CAGNE Surface Access Transport Update – Response to D5 Submissions & ISH8

Sterling Transport Consultancy Limited

15 July 2024

Section 7 - Airport Way Westbound (Railway Bridge To North Terminal Flyover)

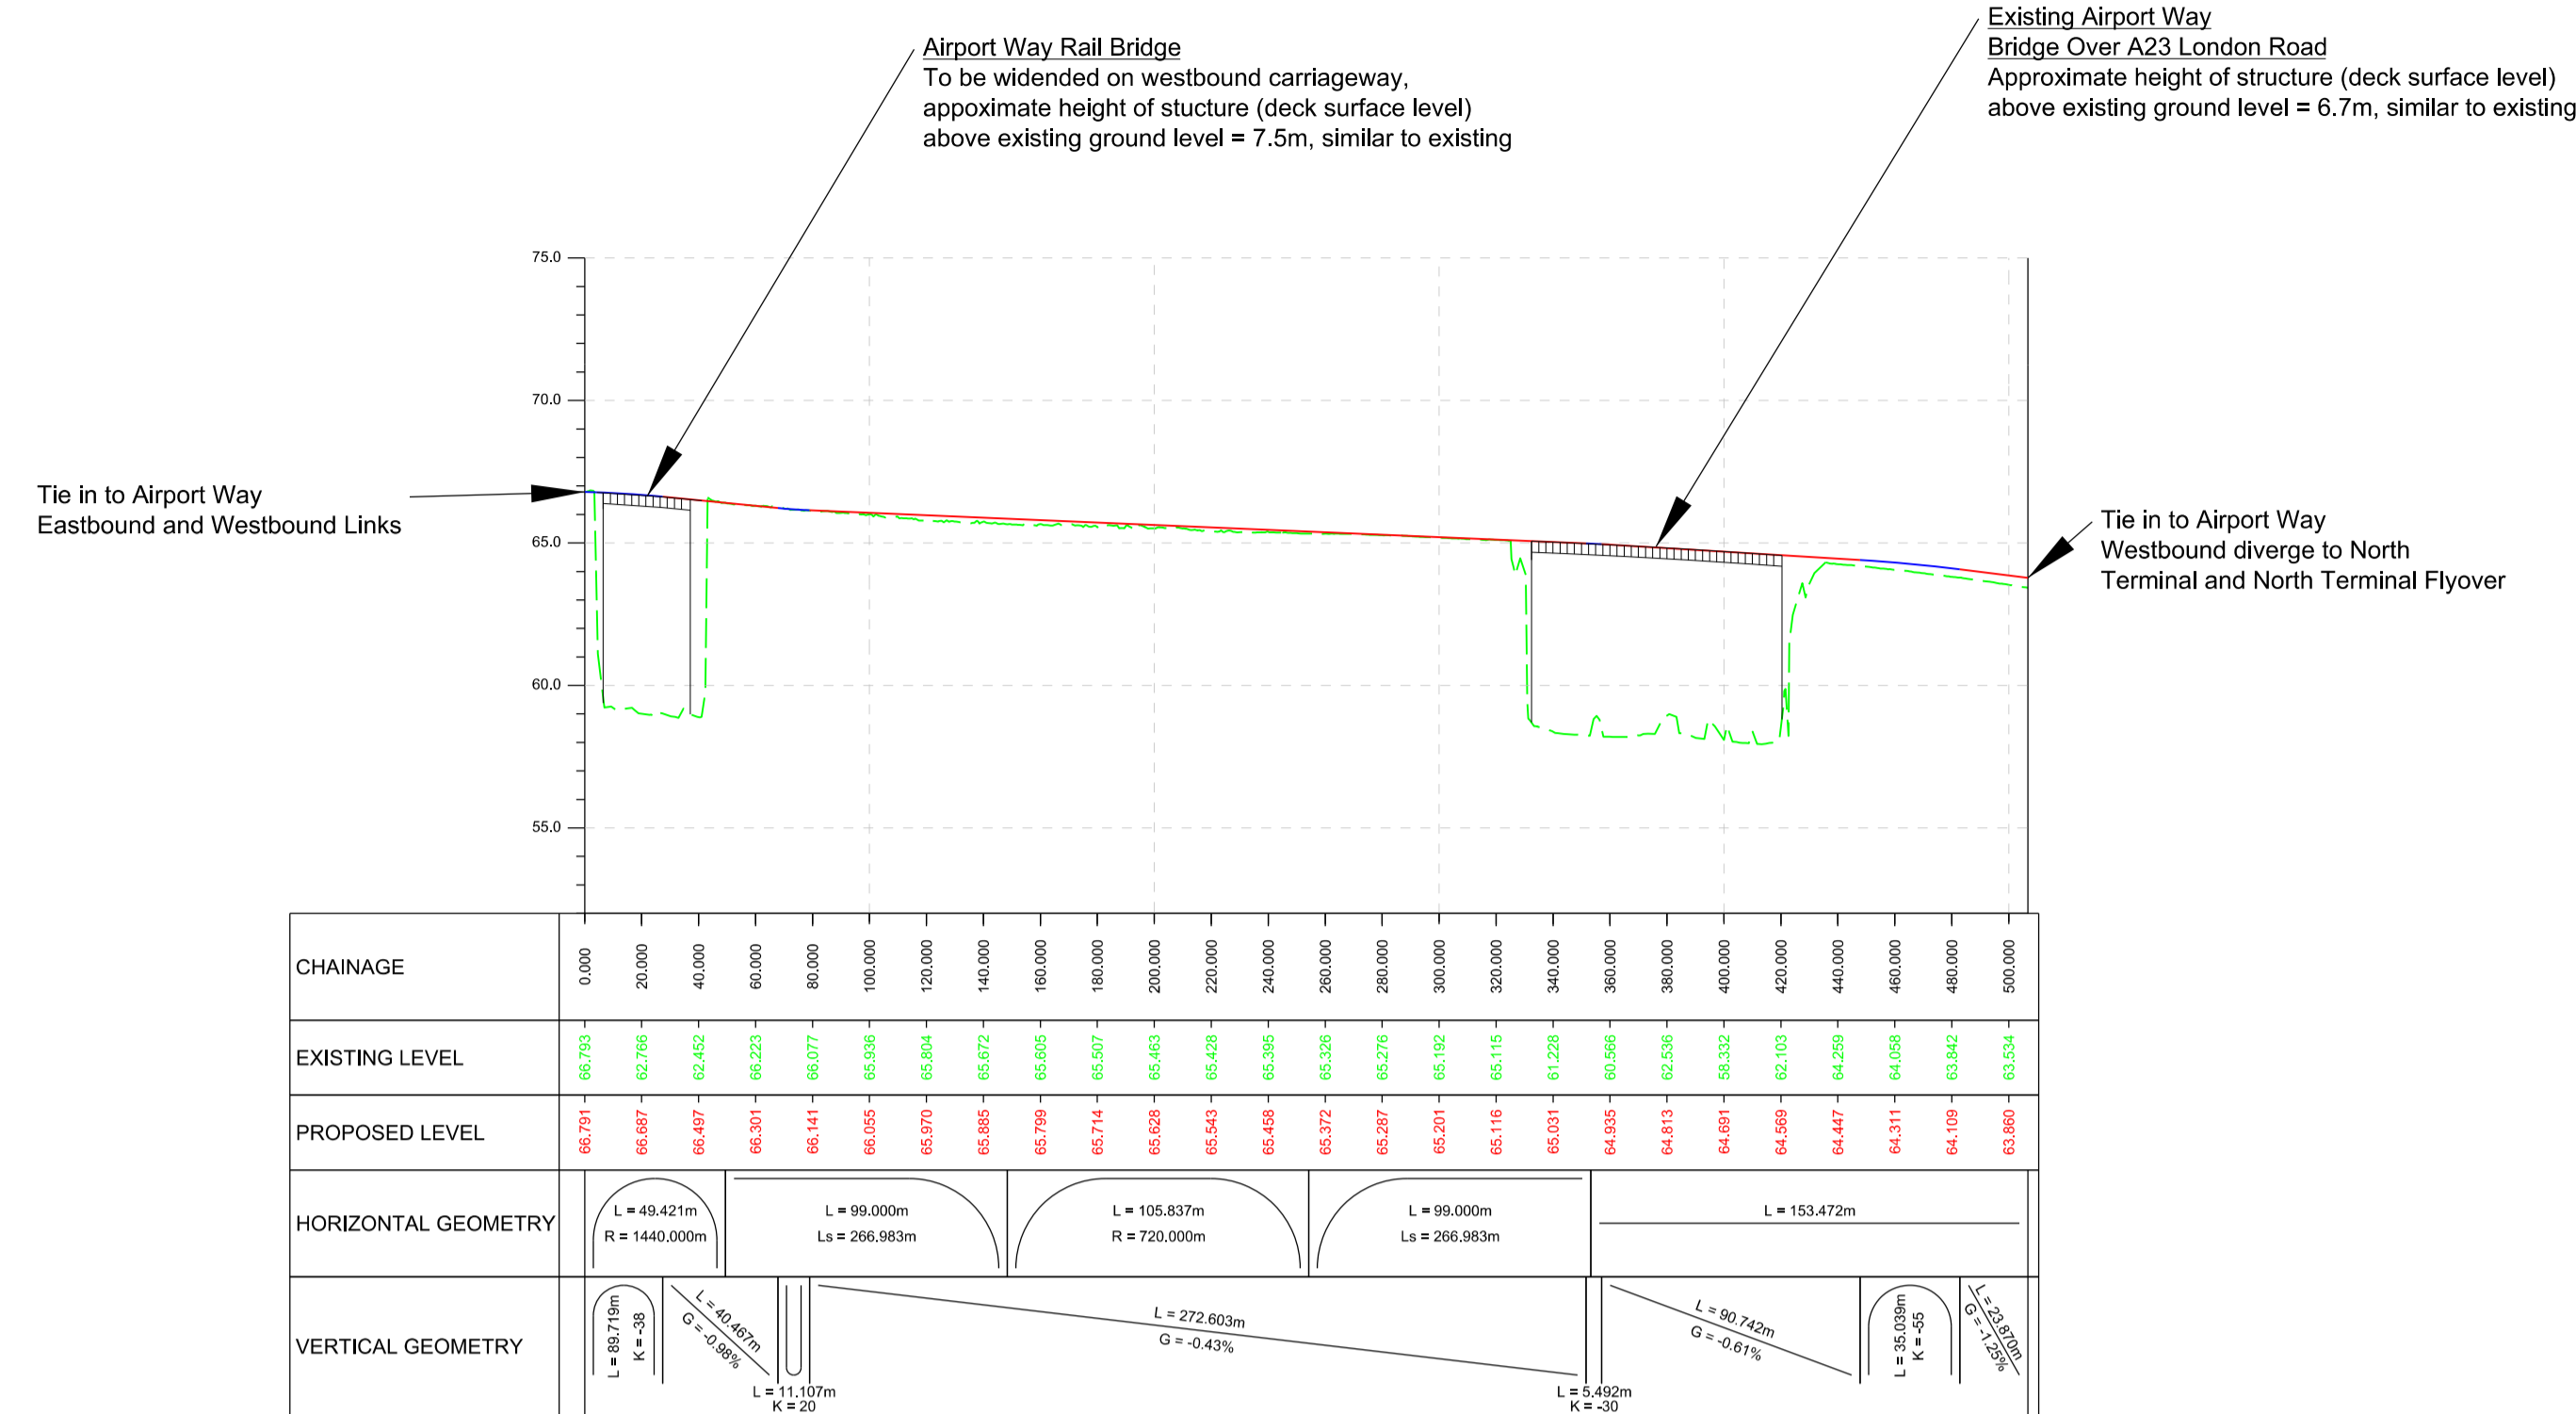
The ES scope of works highlights that the Brighton mainline (railway) would need to be closed to allow works on the Airport Way bridge to take place. It is not clear from the information supplied whether these closures would take place within the standard Network Rail engineering access periods or be disruptive possessions outside of the times the line is usually closed for engineering works (essentially 2345 Saturday to 0840 Sunday each week with some diversion between fast and slow lines). The impact of disruptive possessions which would appear to be a complete blockade of the railway line for these bridge works will be significant given the likely need for complete and extended closures of the line. This state of affairs has received no consideration in any element of the transport or construction analysis presented by the applicant. Network Rail in their representations have not commented on the acceptability of the approach proposed by the

applicant in relation to these works nor offered confirmation that the appropriate agreements for the works to be conducted are capable of being entered into.

CAGNE considers that the approach of the applicant which appears to be to make consideration of the detail of the rail line closures at a later stage where the impact on local communities may not be assessed as flawed. The applicant should expose to the examination its strategy for the bridge works setting out the length and timing of closures of the rail line required (and presumably the closures of Airport Way link also). The applicant should also be explicit as to the measures to be put in place to replace rail services curtailed by their works and how this would affect the ability of mode share targets to be met should the closures be a long-term matter.
